Concerning Planning Application 2021/62/90980/E - re the former Chartist Pub, Skelmanthorpe

My comments relate to the **west elevation** of the new industrial units proposed to be built behind the former Chartist Public House, Commercial Road, Skelmanthorpe, HD8 9DT.

West Facing Elevation

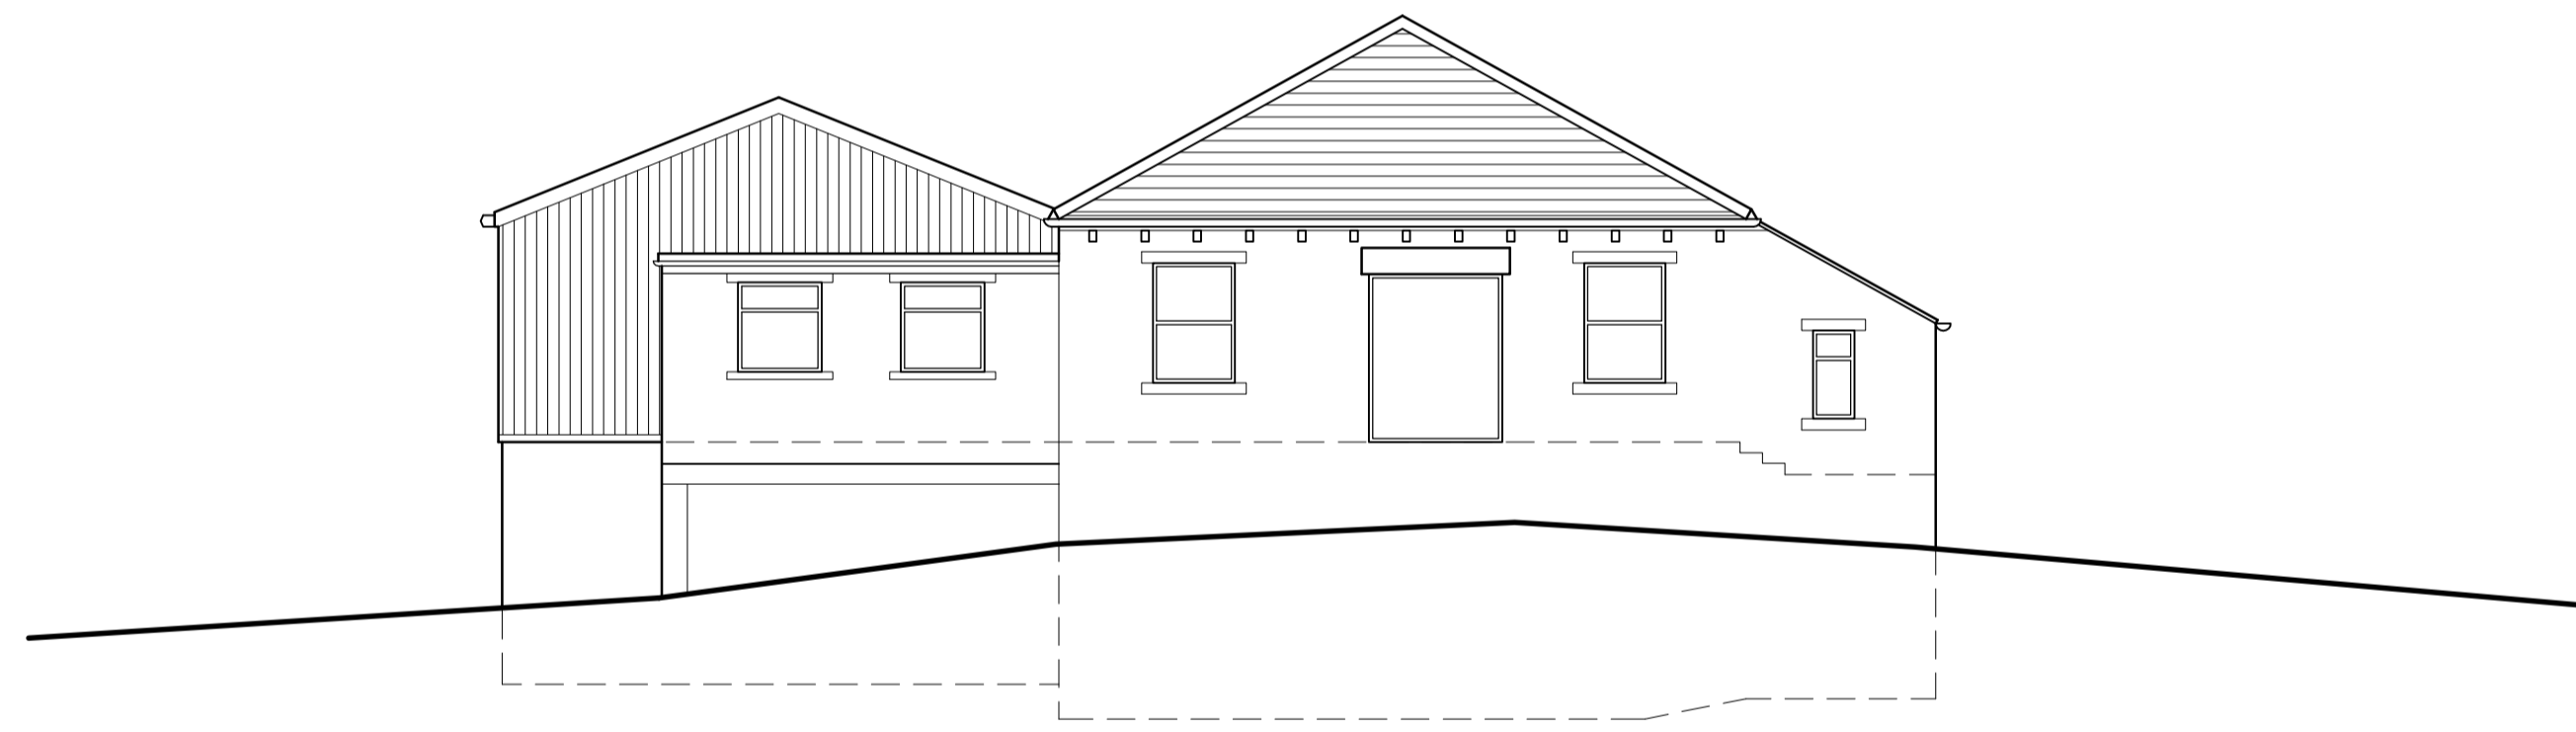
However there should be some natural tree and shrub planting in front of the western elevation of the proposed industrial units - in order to soften the rather monolithic architecture; and also to provide some habitat for wildlife, thus helping enhance biodiversity that should now always be a feature of planning decisions - **ESPECIALLY** since it would seem that some mature trees may be felled?
